ENG-SF23007-R1-FDR.pdf Markup Summary

Waterbury Filings 1 & 2

DESIGNED BY	DLF
DRAWN BY	QNA
CHECKED BY	QNA
H-SCALE	NA
V-SCALE	N/A
JOB NO.	1715.00
DATE ISSUED	2/6/23
SHEET NO.	35 OF 39

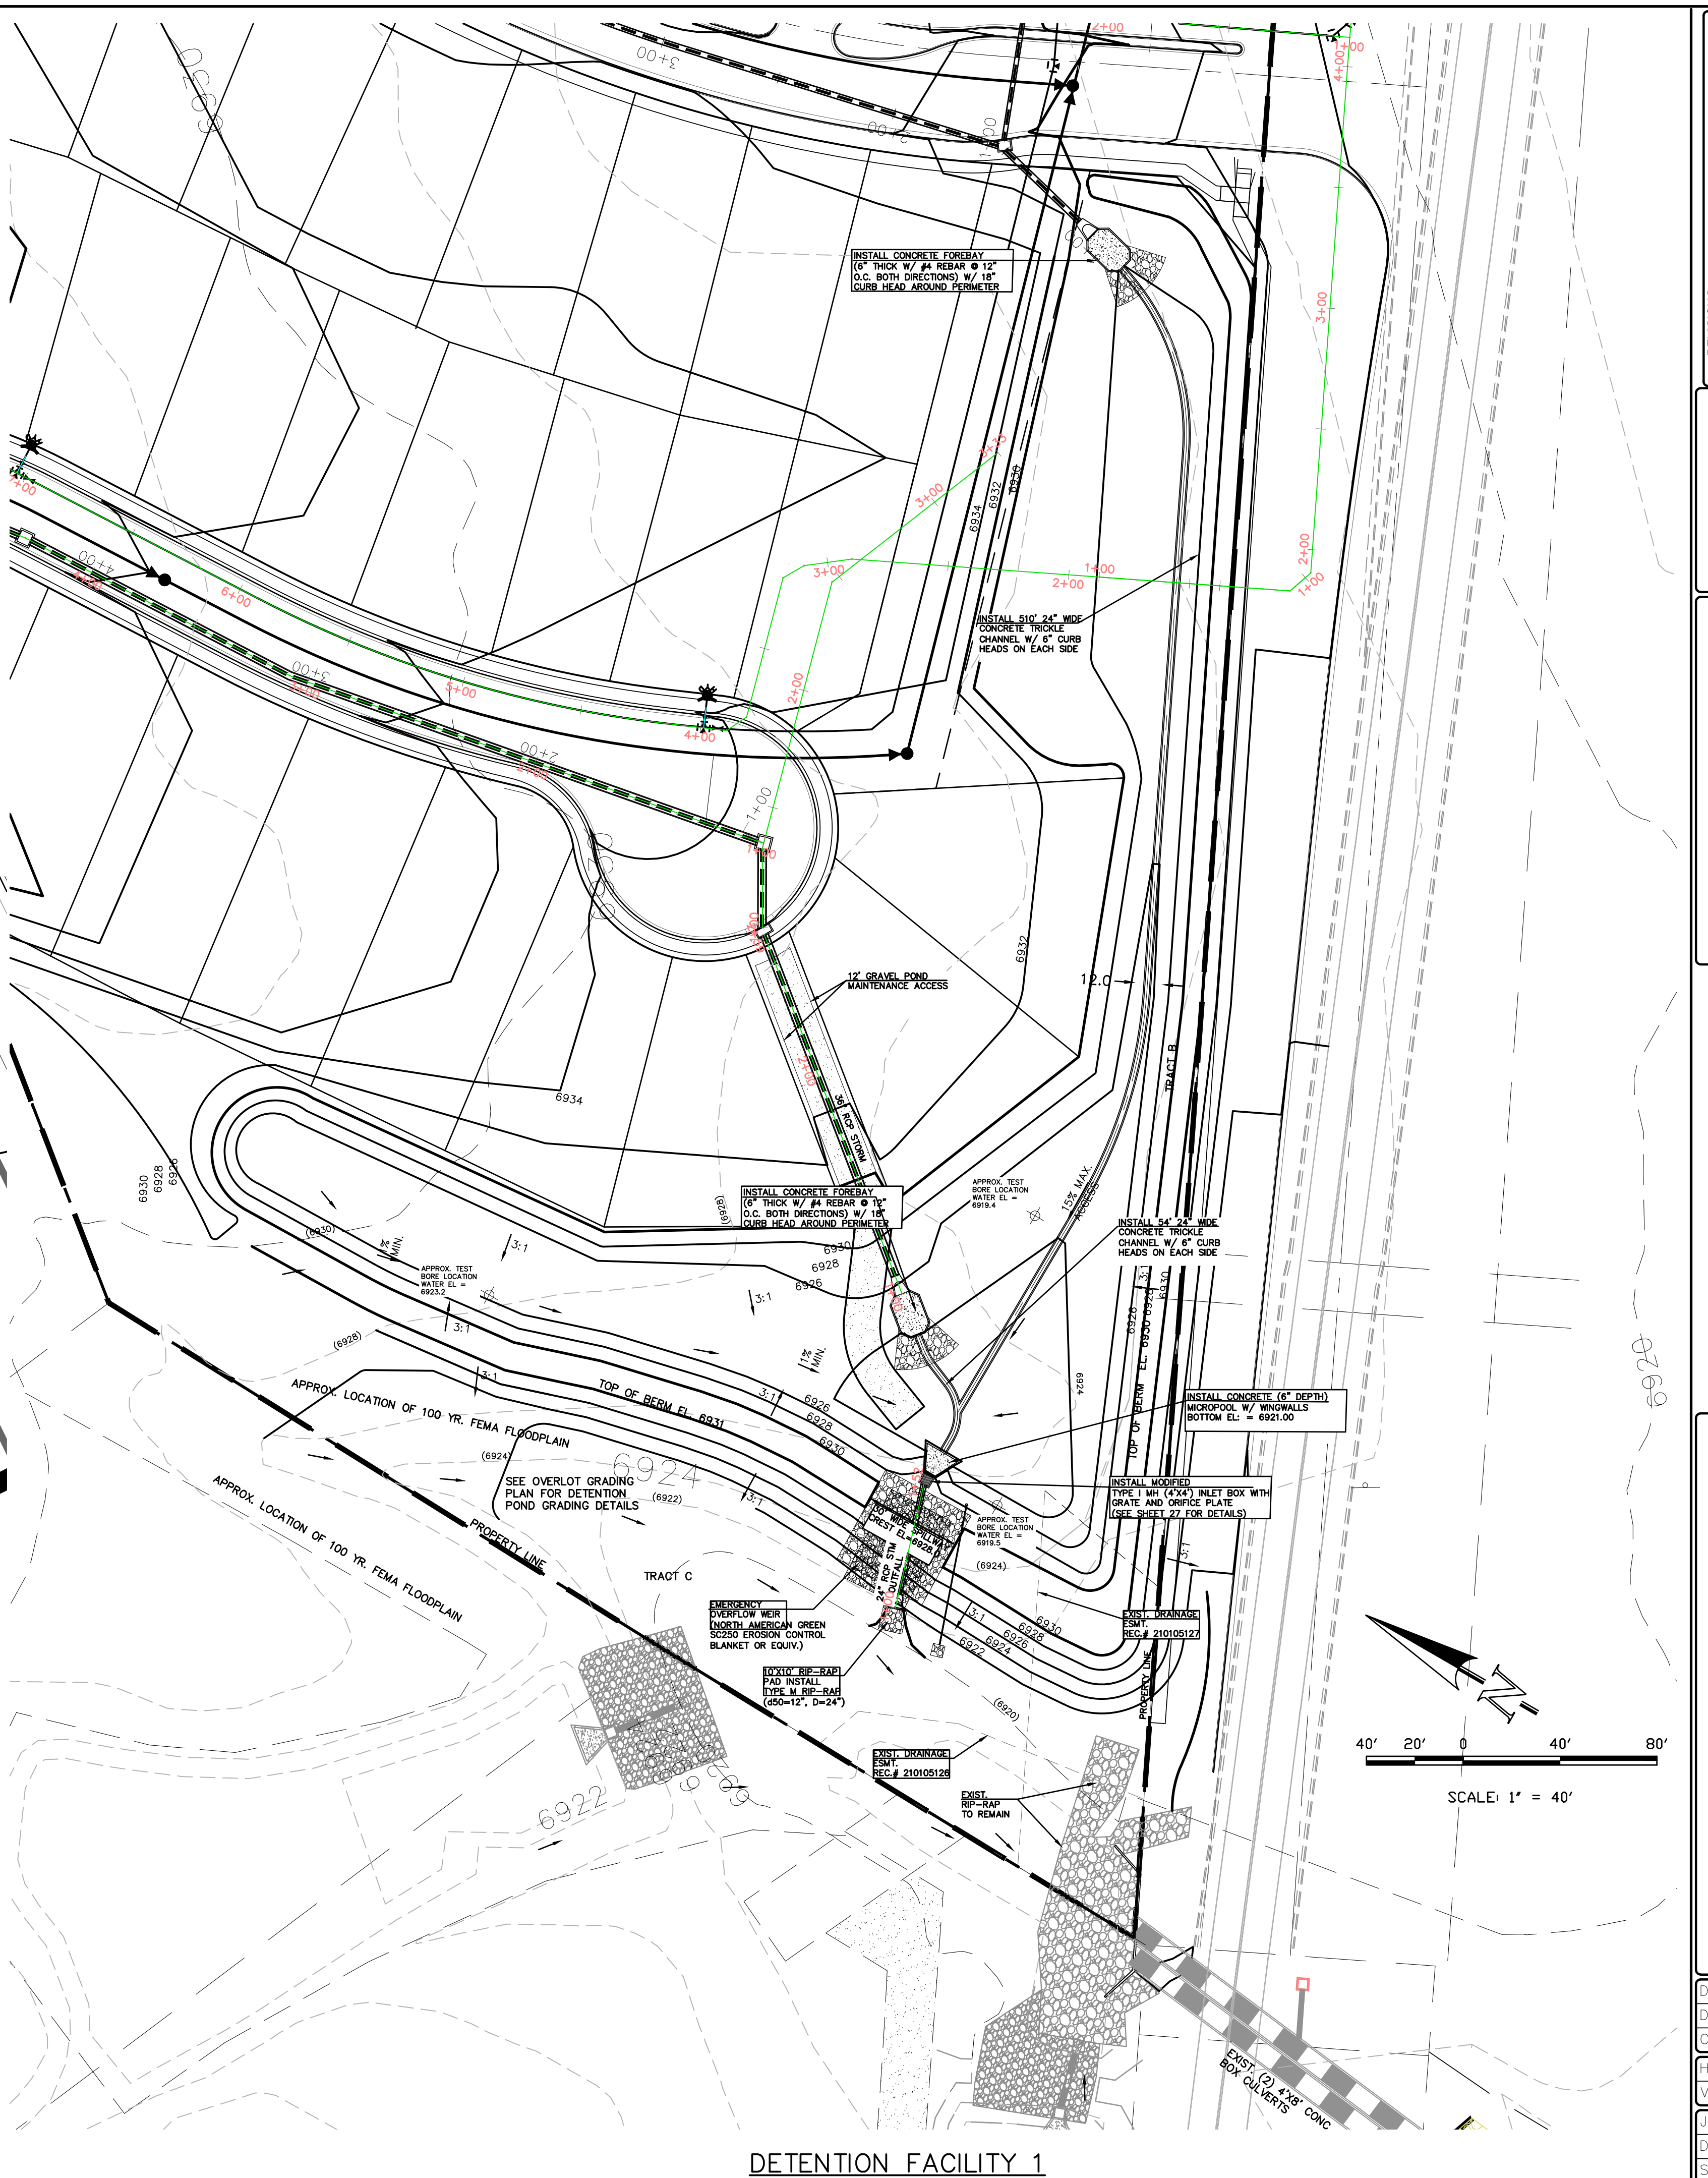
actually only 3ft per detail on sheet 36 of CDs

shown as 3.04 on sheet 36 of CDs

shown as 3.04 on sheet 36 of CDs

DESIGNED BY DLF			
DRAWN BY QNA			
CHECKED BY QNA			
H-SCALE NA			
V-SCALE N/A			
JOB NO. 1715.00			
DATE ISSUED 2/6/23			
SHEET NO. 37 OF 39

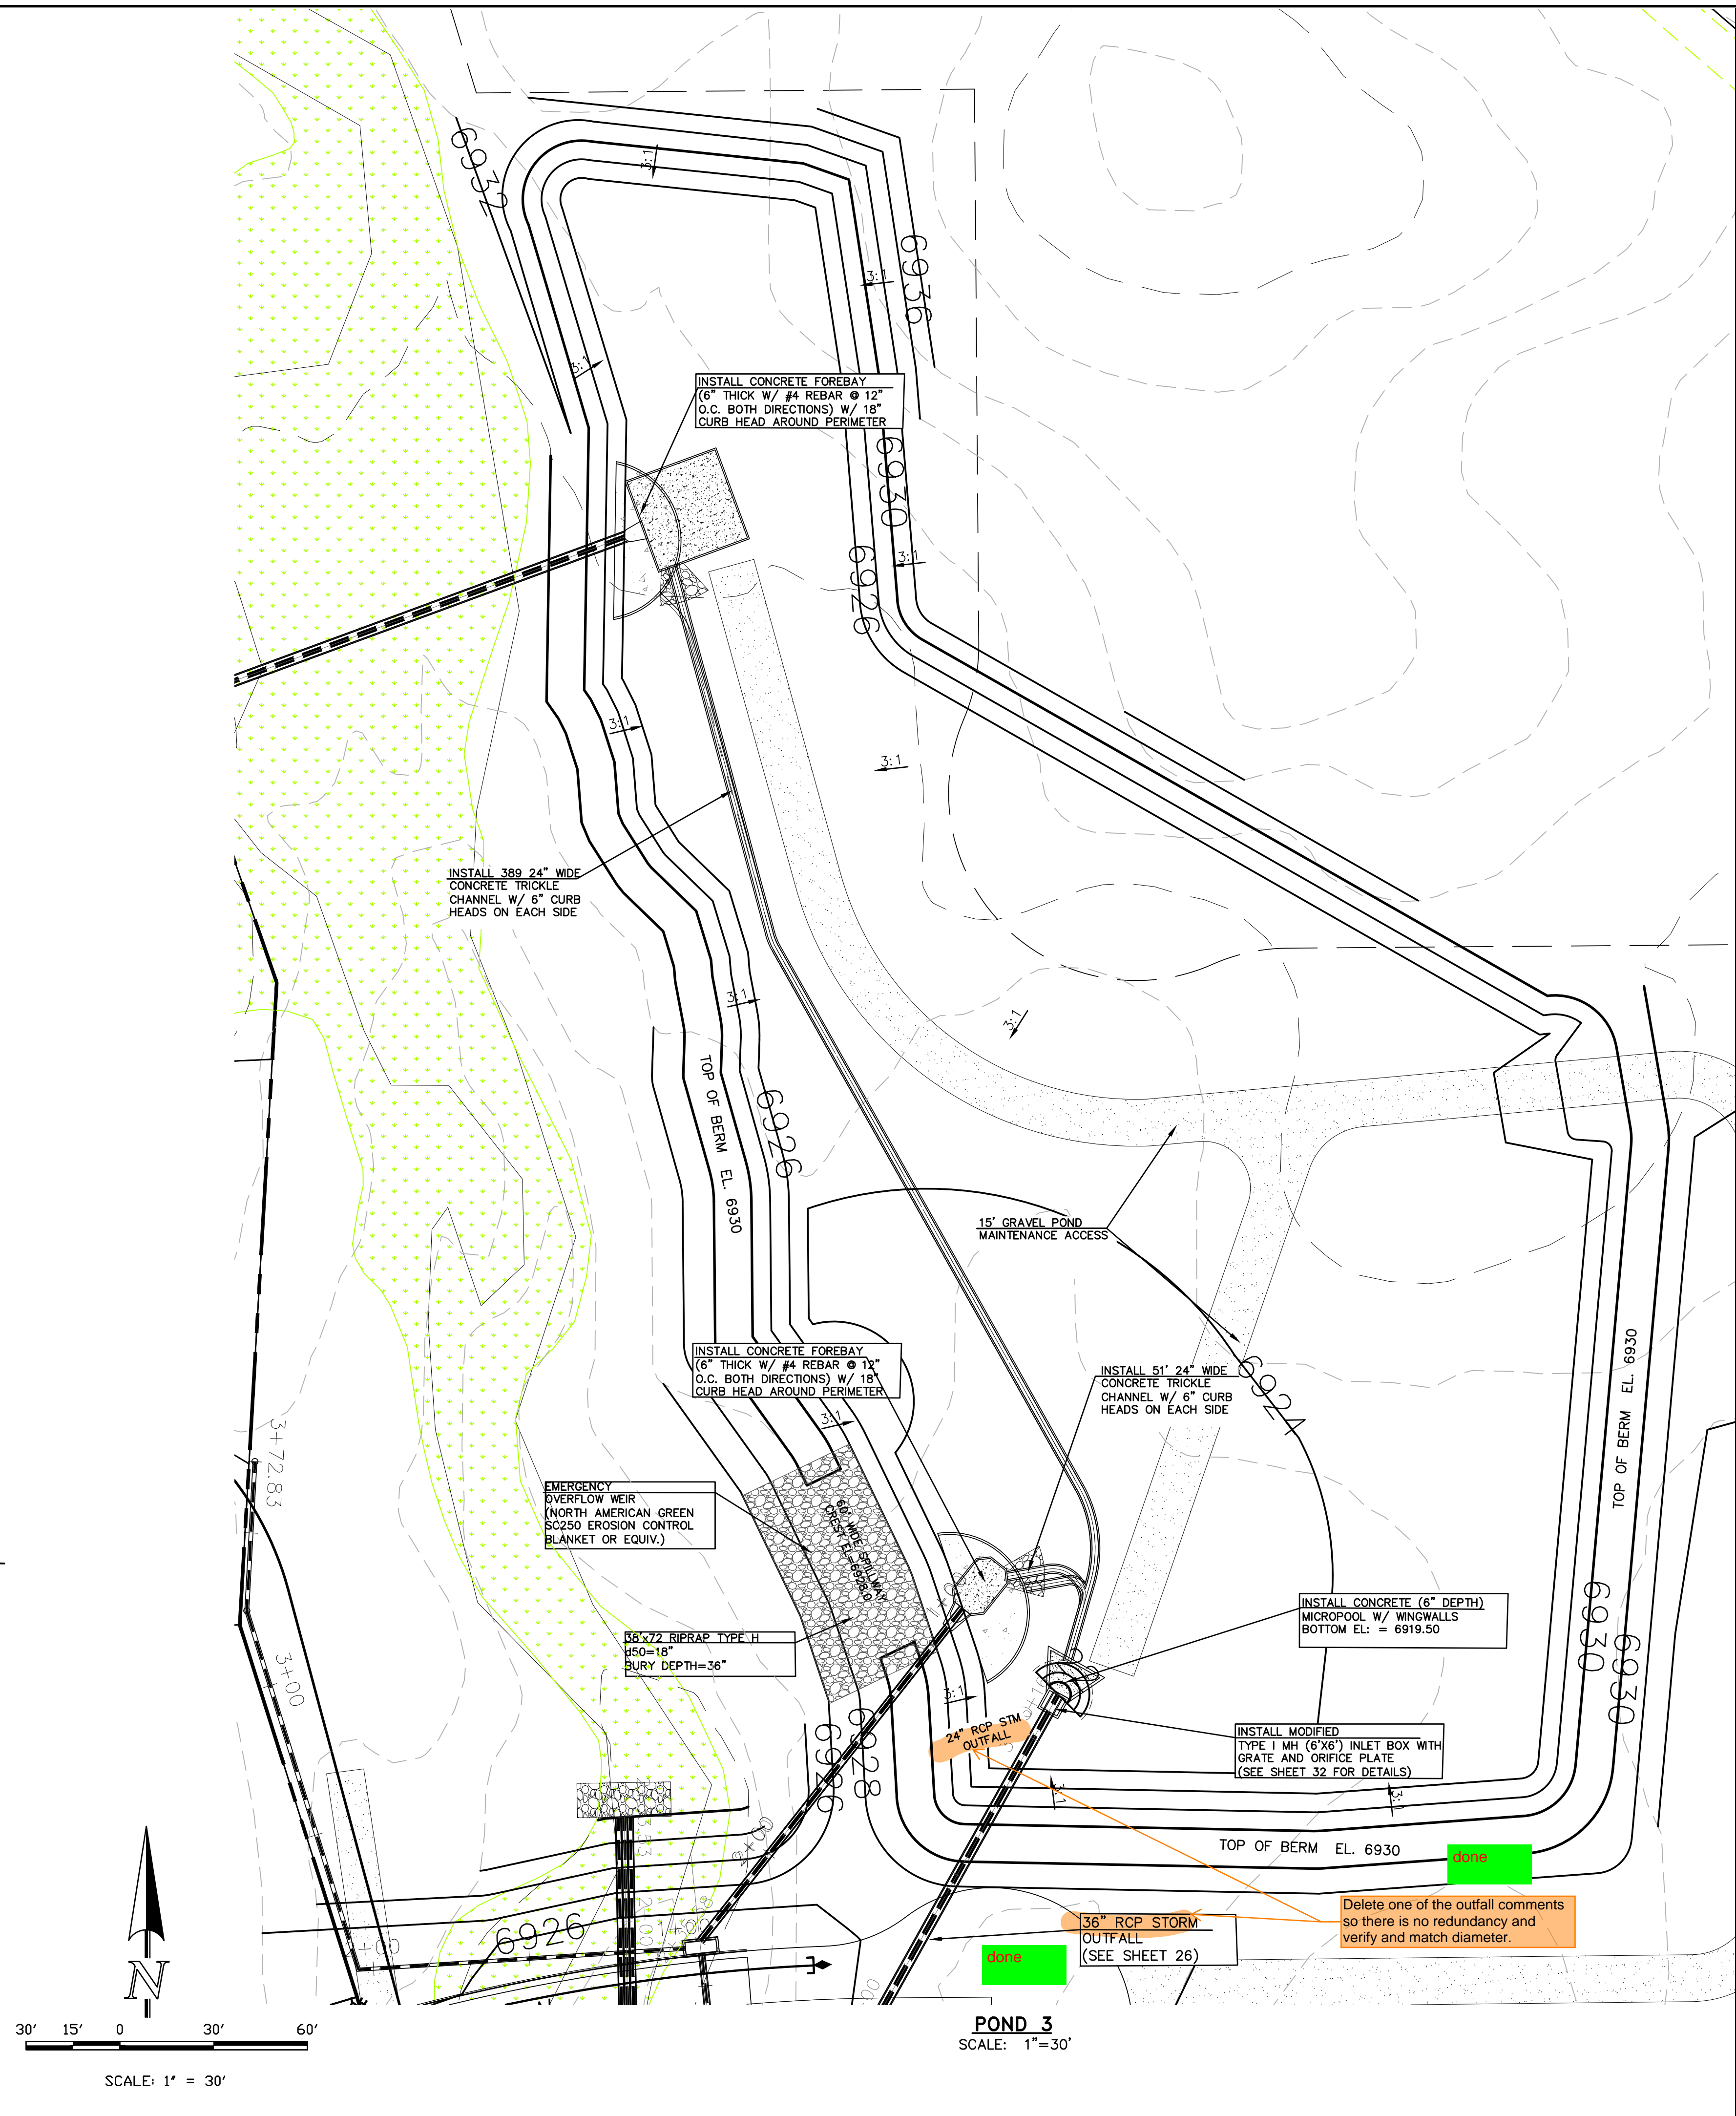
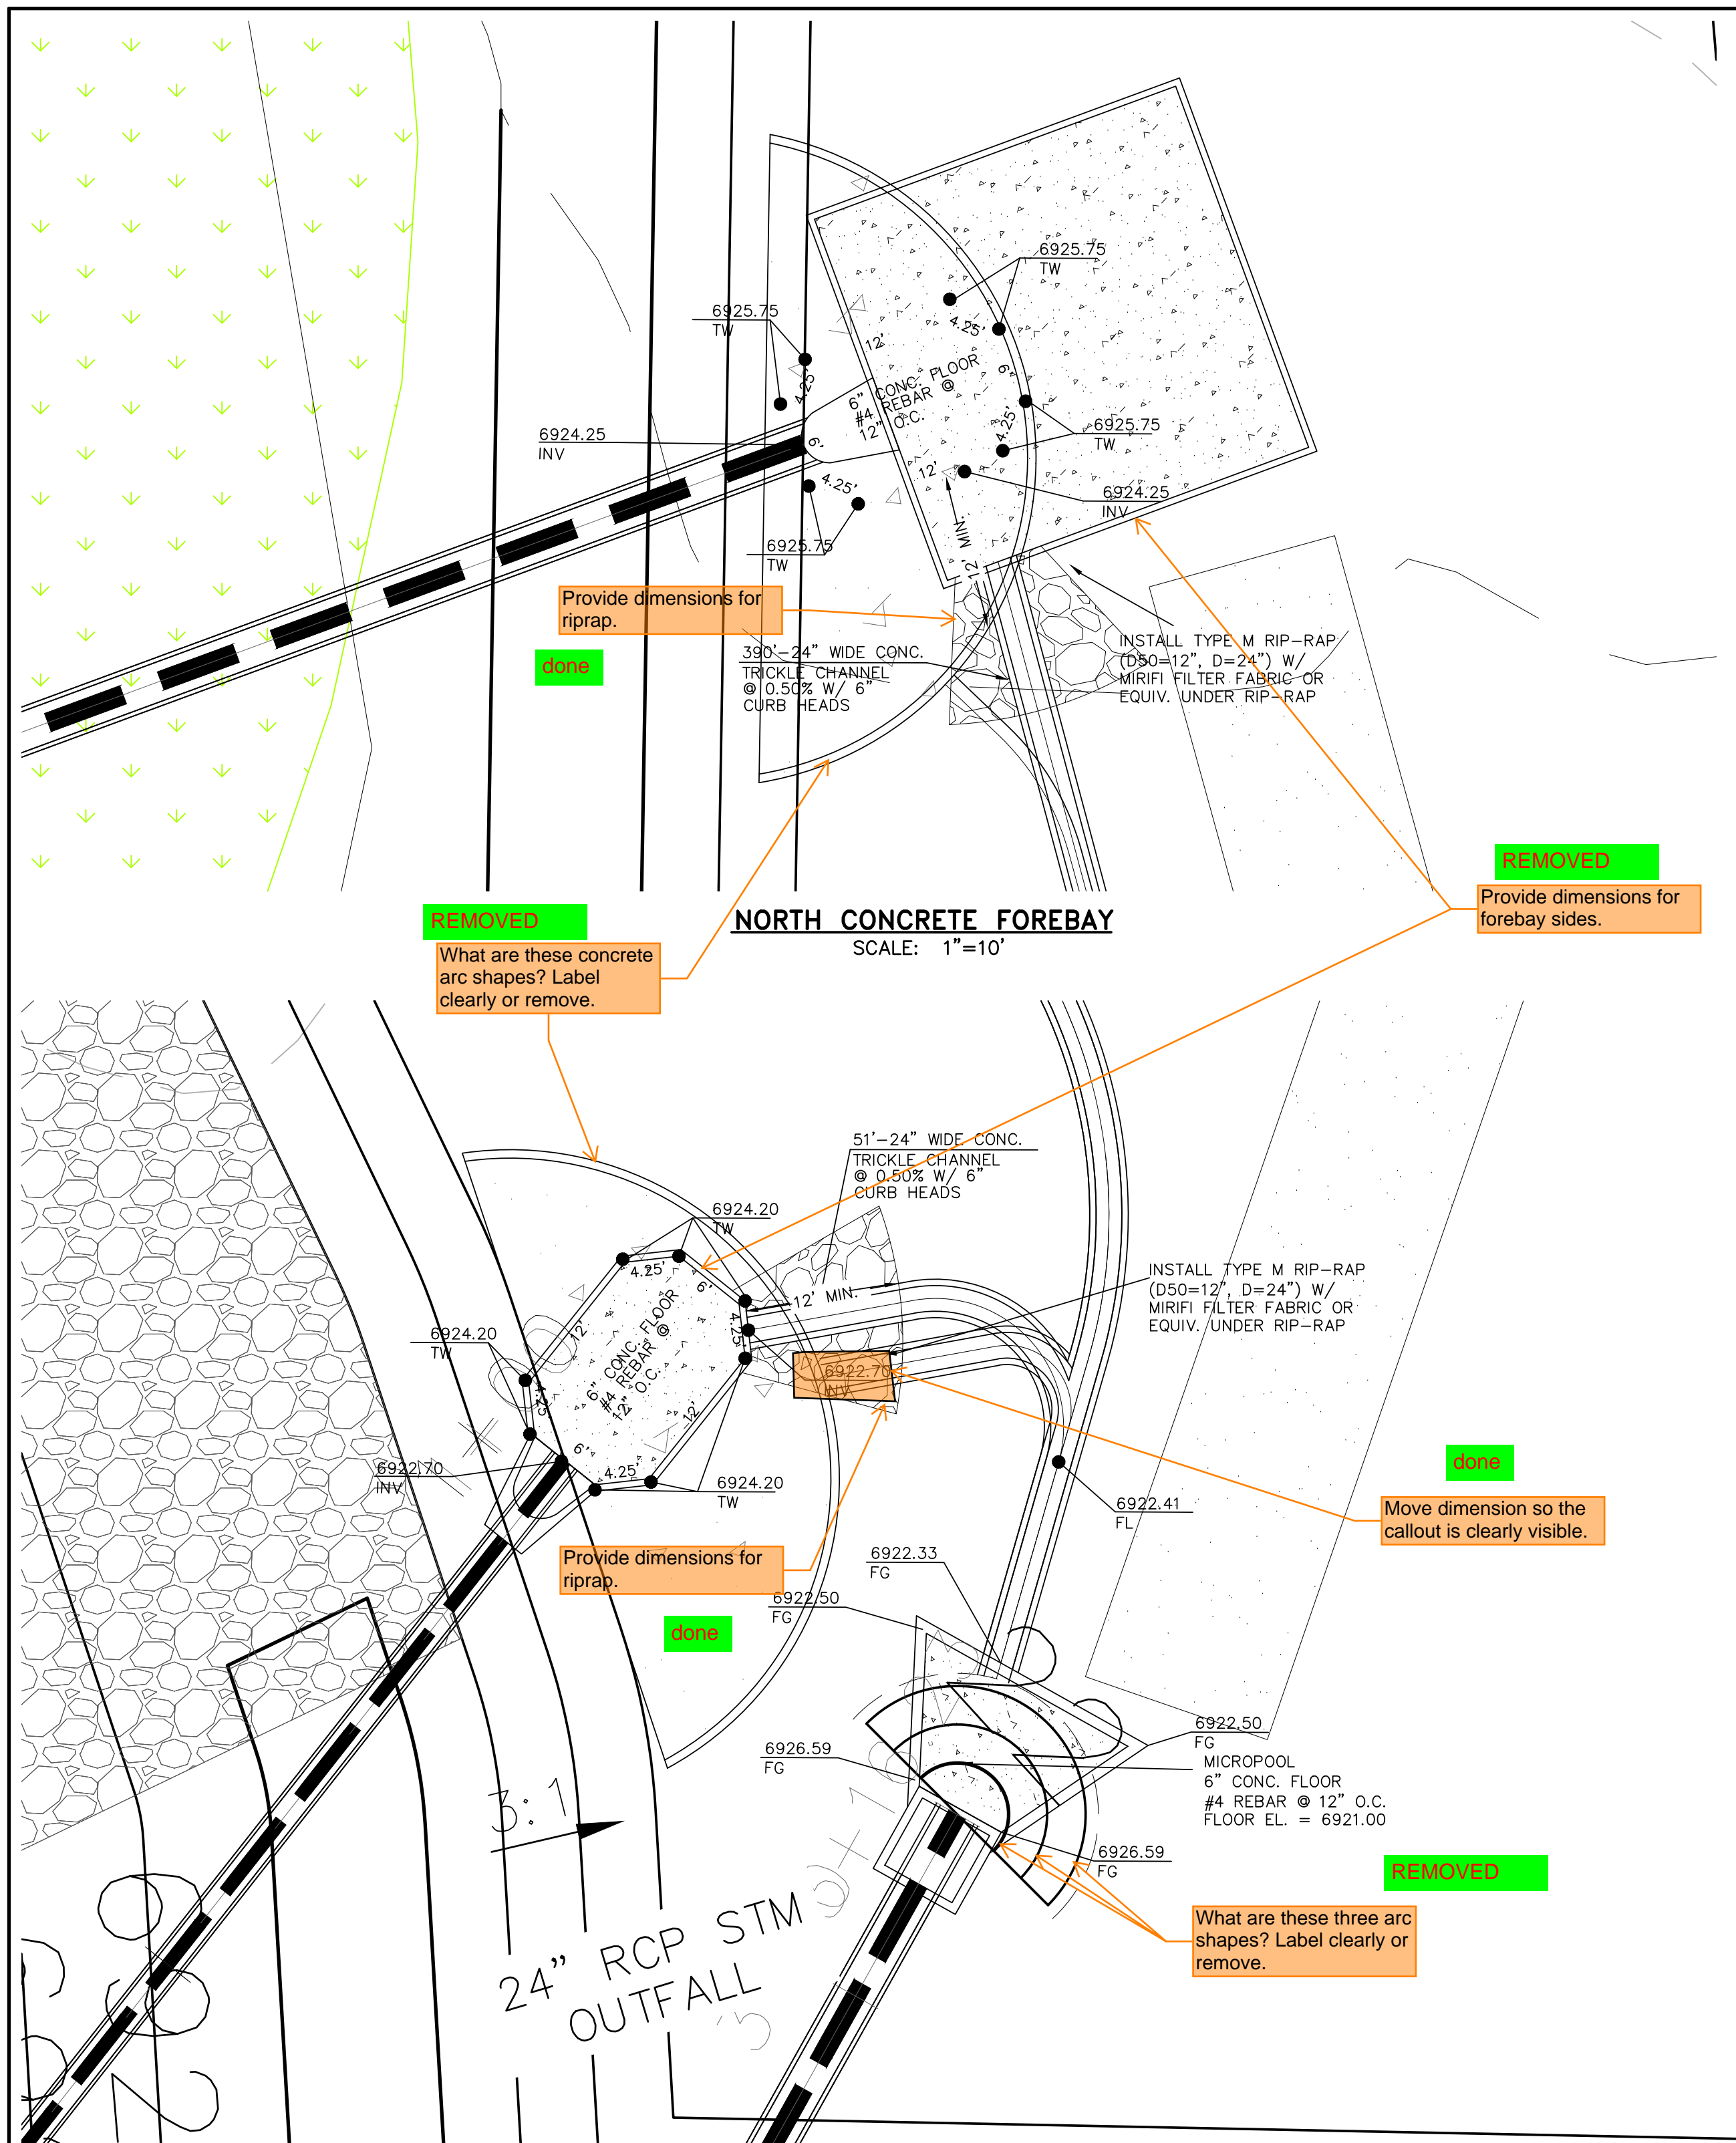
Please provide a little more detail on the sequencing and how the pond might be modified in the future. Because Sheet 37 of CDs labels the pond as "interim" but the forebay as "permanent." So in the report here, clarify what is temp vs what is permanent and/or adjust the labeling in the CDs to be consistent and more clear.
